Our Ref: M/17/19/PL

**Town & Country Planning Act 1990 (as amended)
Town and Country Planning (Development Management Procedure) (England) Order 2015
Application for Full Planning Permission**

Development 1 No. 1-bedroom dwelling (resubmission following M/99/18/PL).
Location 14 Baldwin Close Middleton-On-Sea

AR-129-03/A

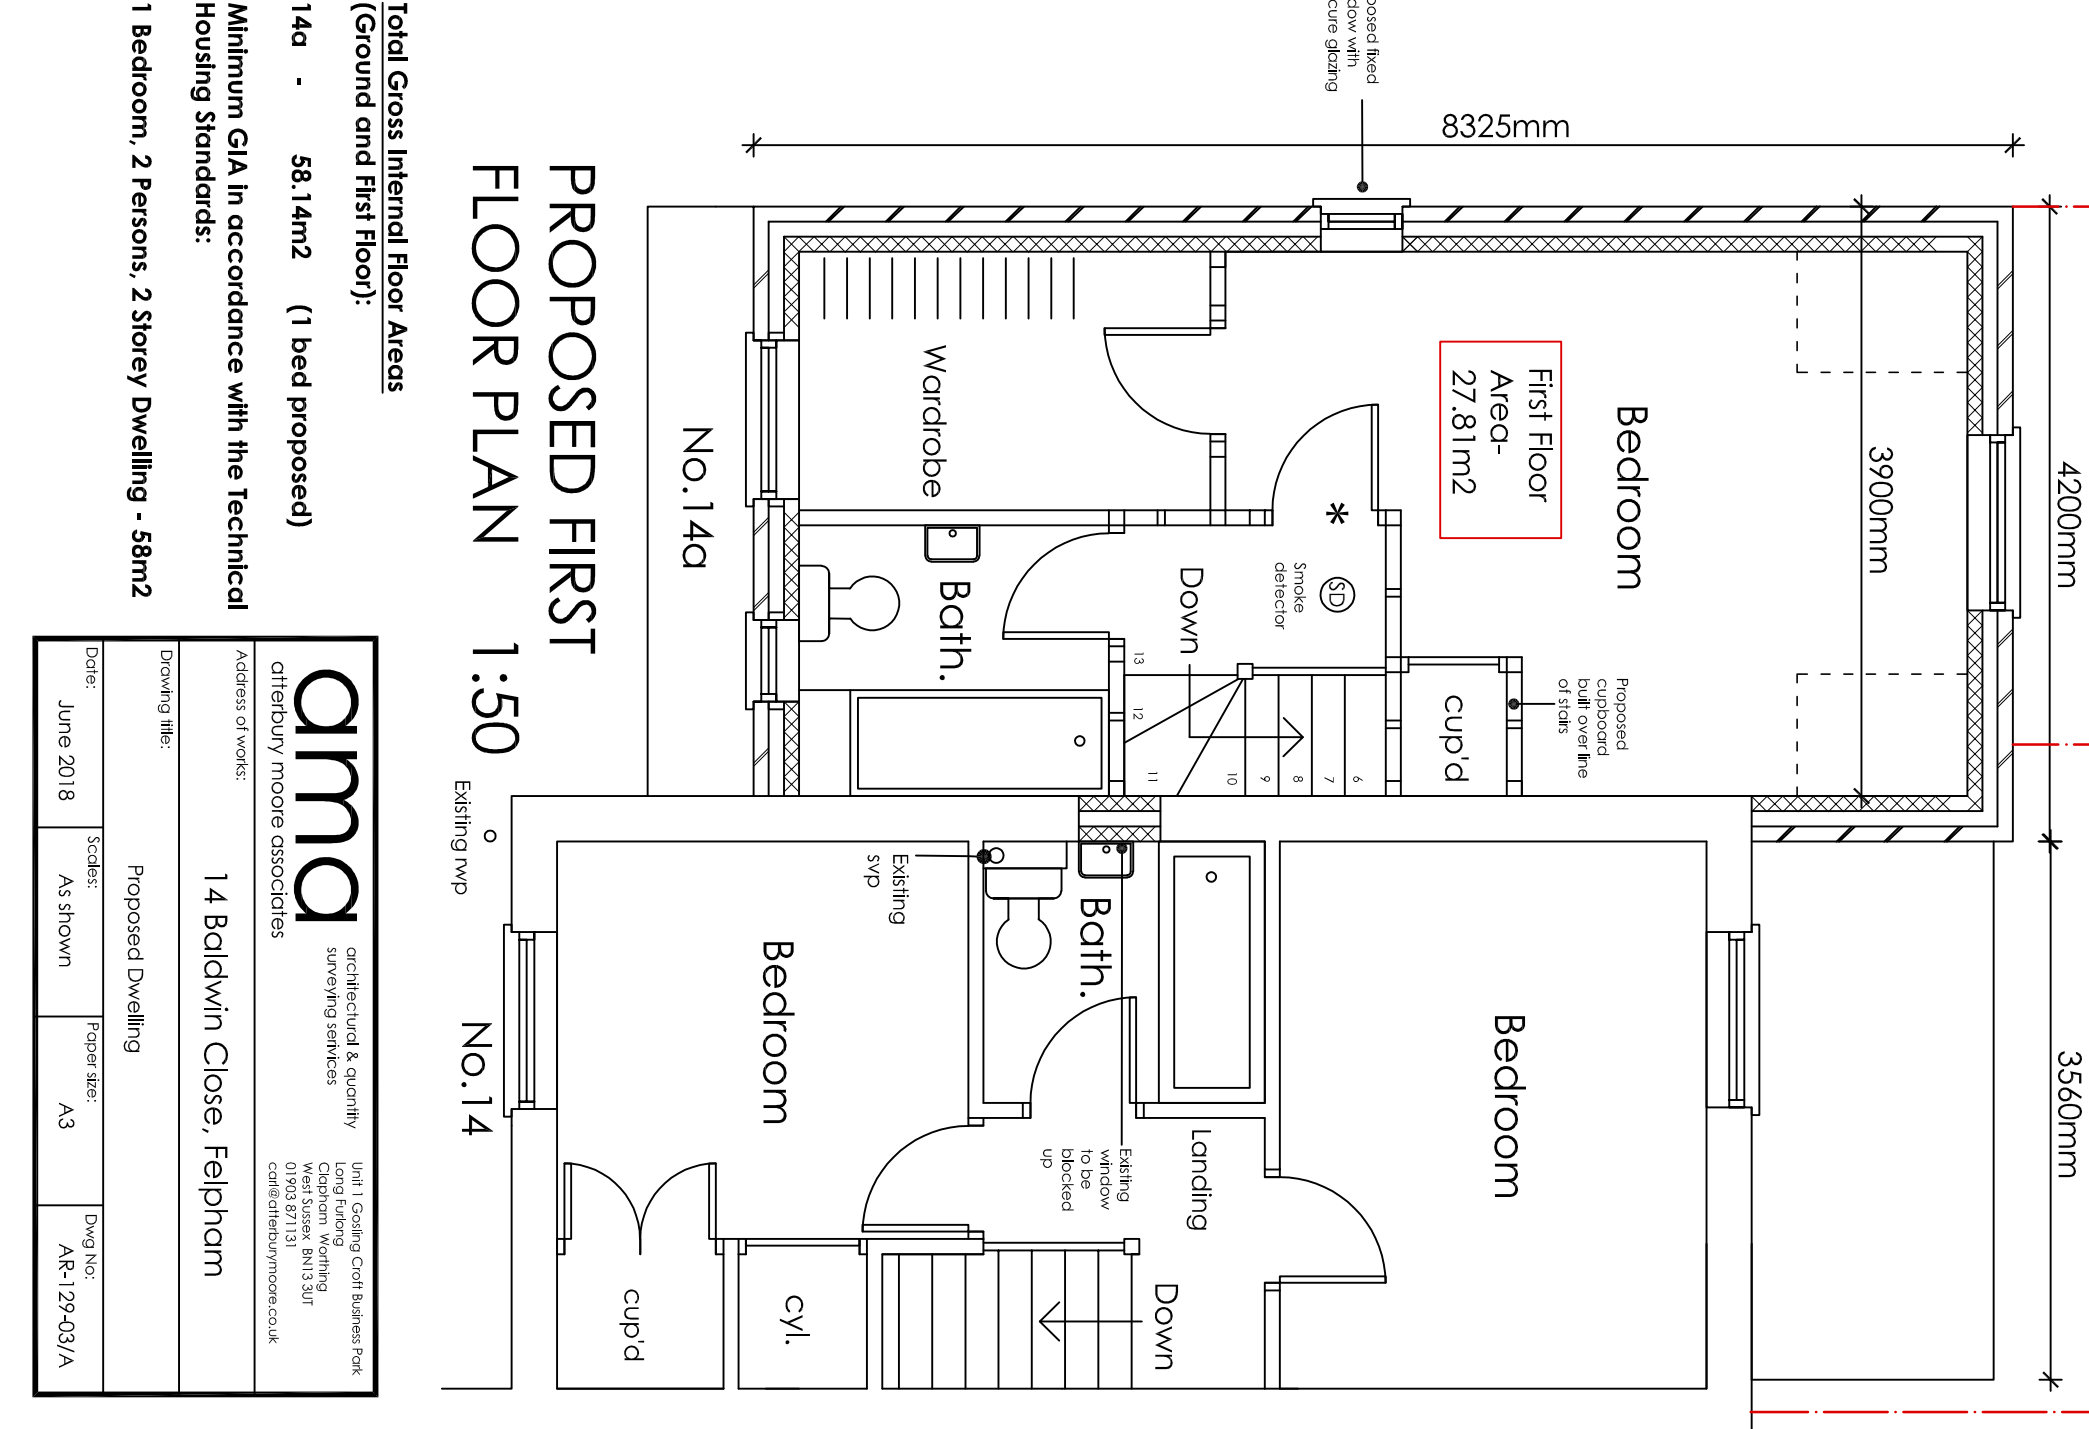
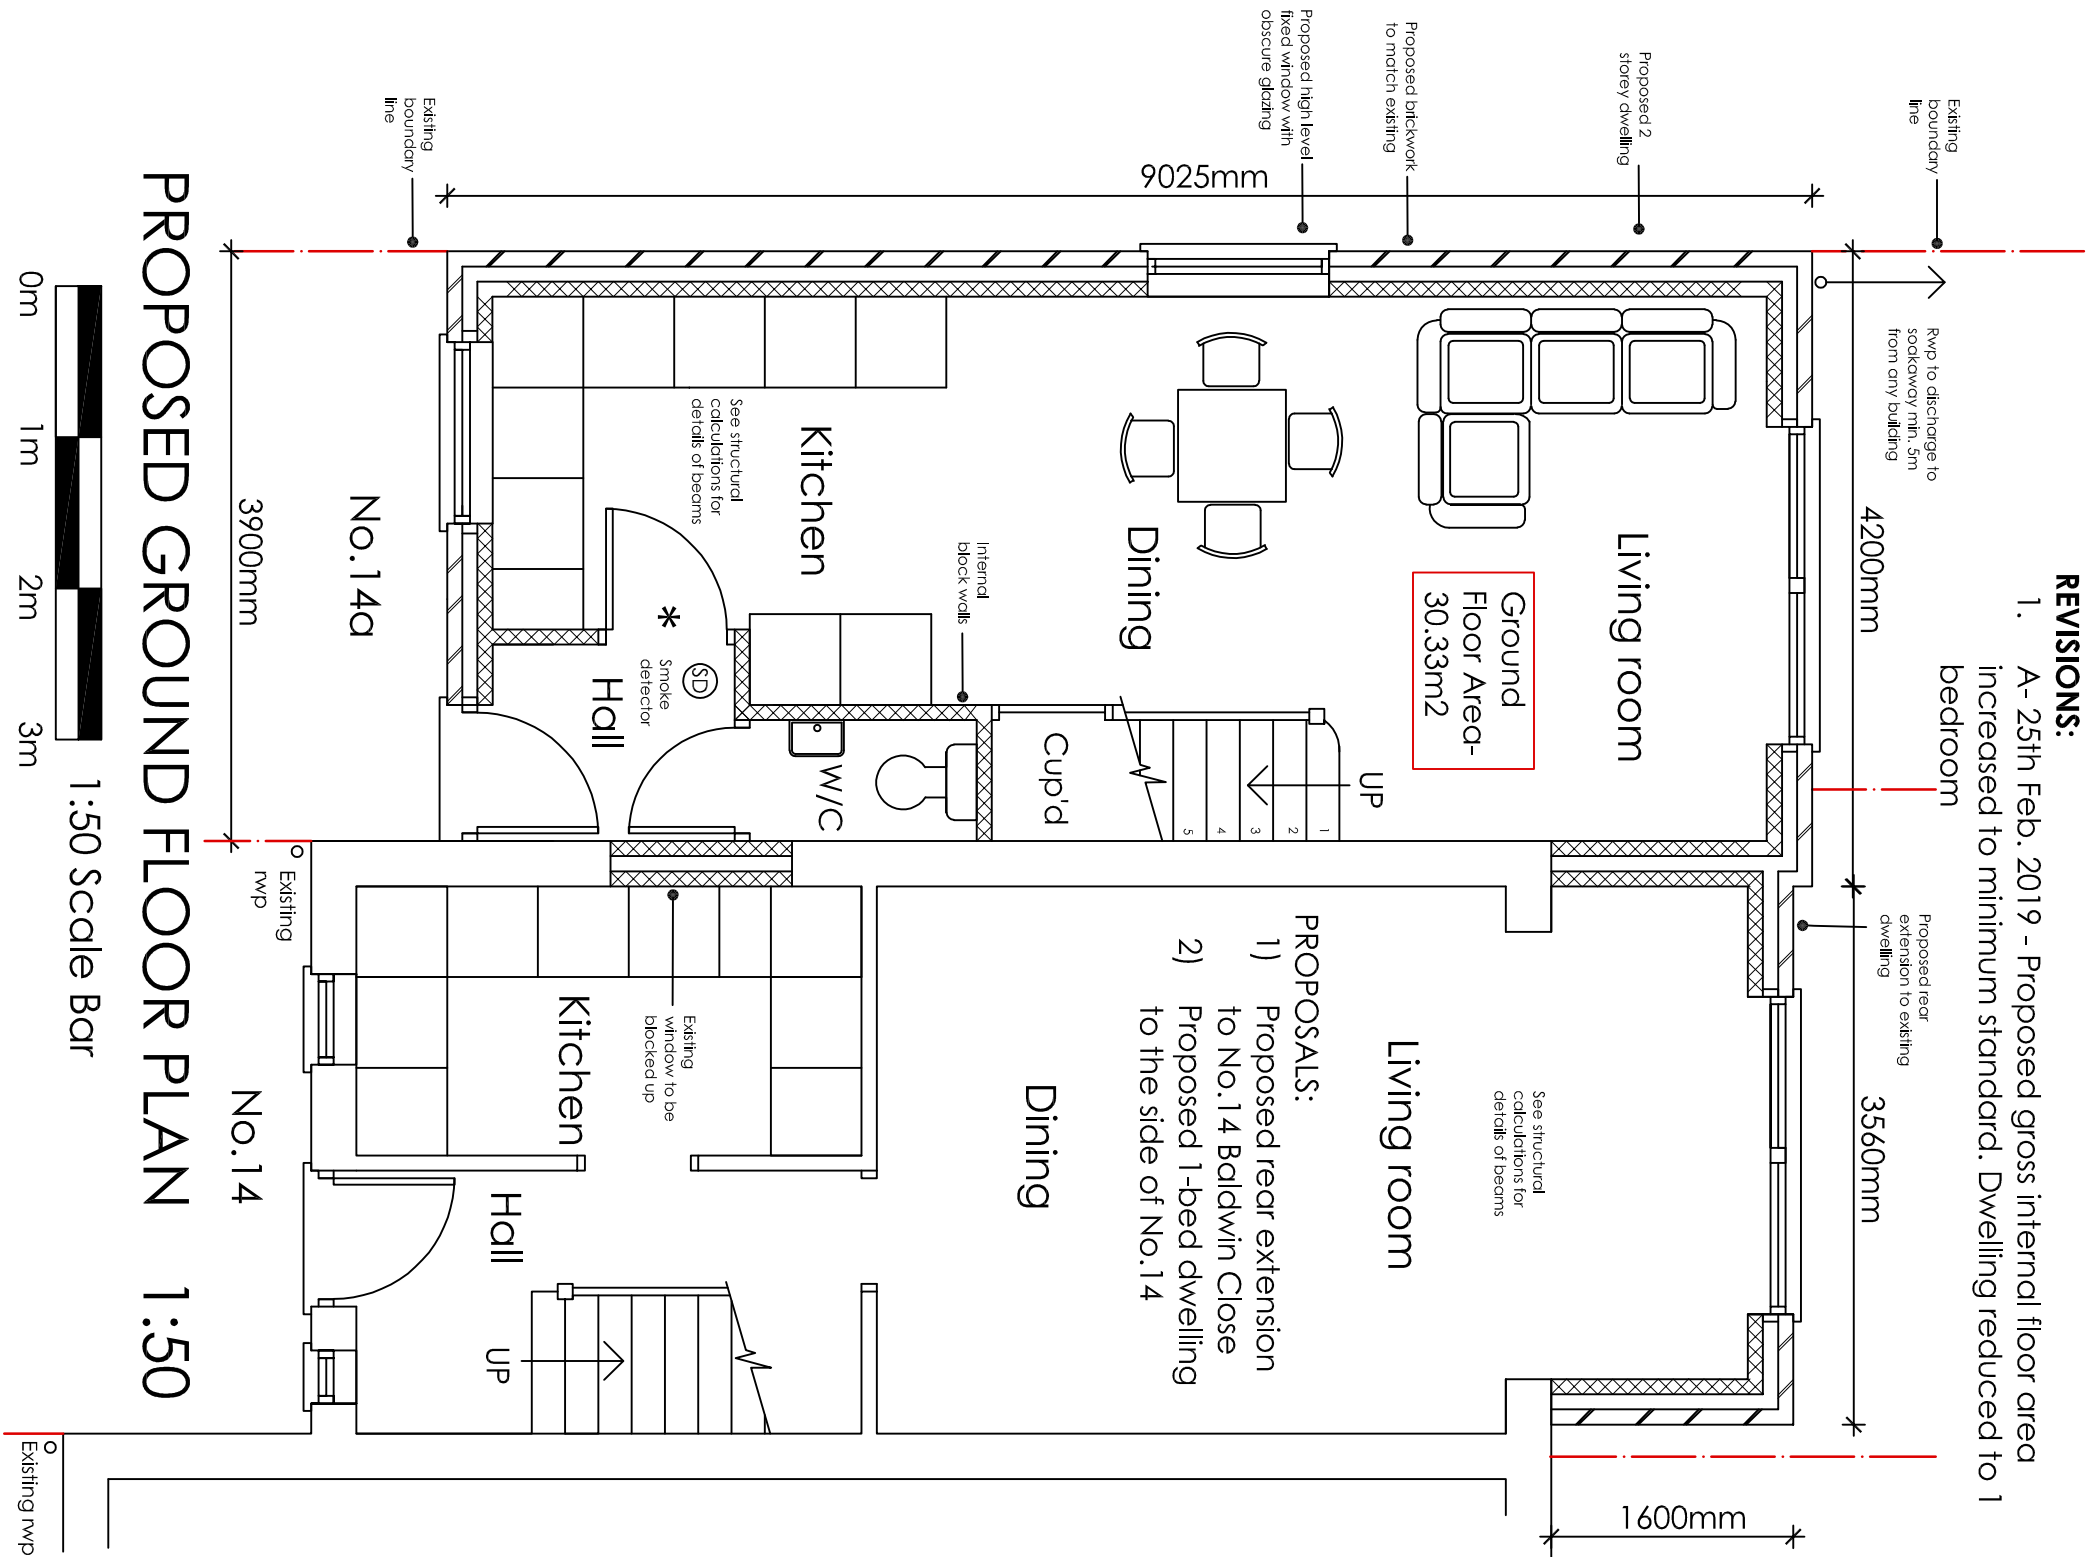
On the garden plan, the new dwelling has been annotated as a '2 bed dwelling'. Please change to '1 bed dwelling' or take number off to read 'dwelling' to avoid confusion.
